DRAINAGE AND TRANSPORTATION INFORMATION SHEET

PROJECT TITLE: Acropolis Parking Structure ZONE MAP/DRG. FILE #: K-14/D74
 DRB #: _____ EPC#: _____ WORK ORDER#: _____

**RE: RESPONSE TO COMMENTS DATED FEBRUARY 7, 2000
ACROPOLIS PARKING STRUCTURE
ALBUQUERQUE, NEW MEXICO**

RE: Acropolis Parking Structure(K-14/D074)

GRADING AND DRAINAGE PLAN

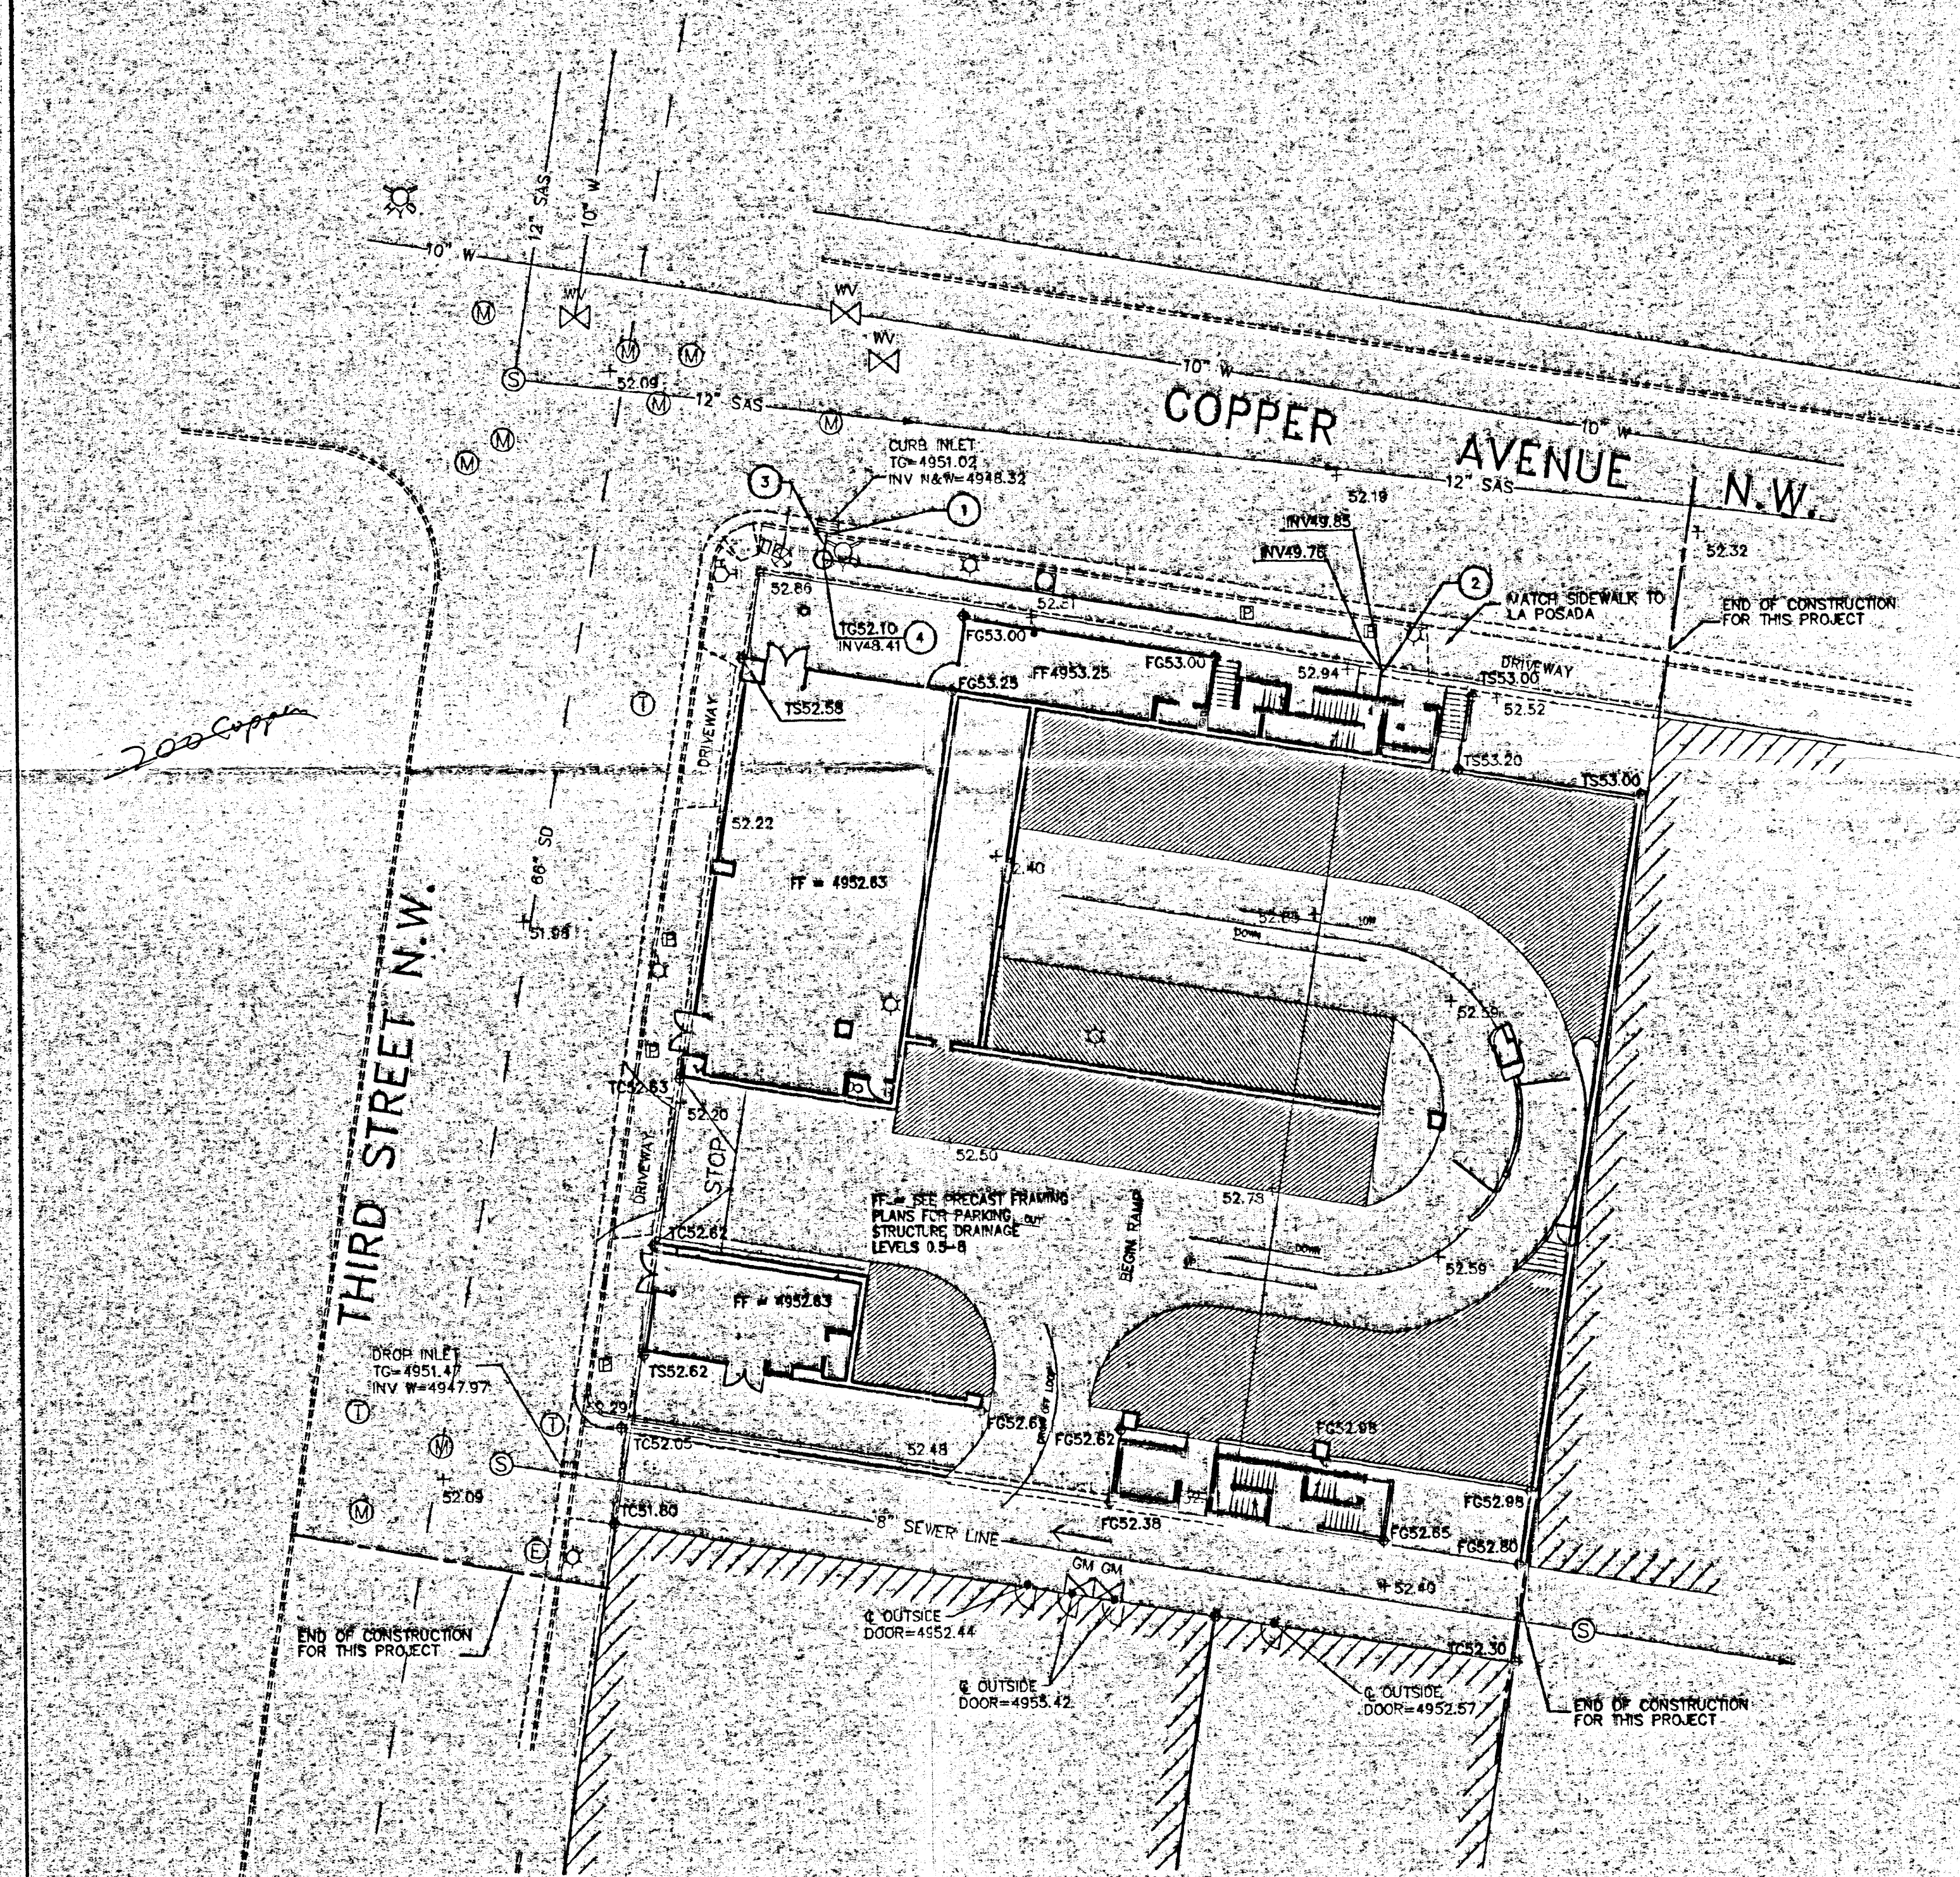
I have reviewed your submittal for the project referred to above and offer the following comments:

1. The building drains to the north and is routed to the back of the existing catch basin on Copper Ave. at 3rd Street. The sidewalk culvert has been removed.
2. The only utility in 3rd Street is the 66" Storm Drain, which is now shown on the revised plan. Water and Sanitary Sewer do not run in 3rd Street.
3. The S.O.19 has been included on the revised plan.
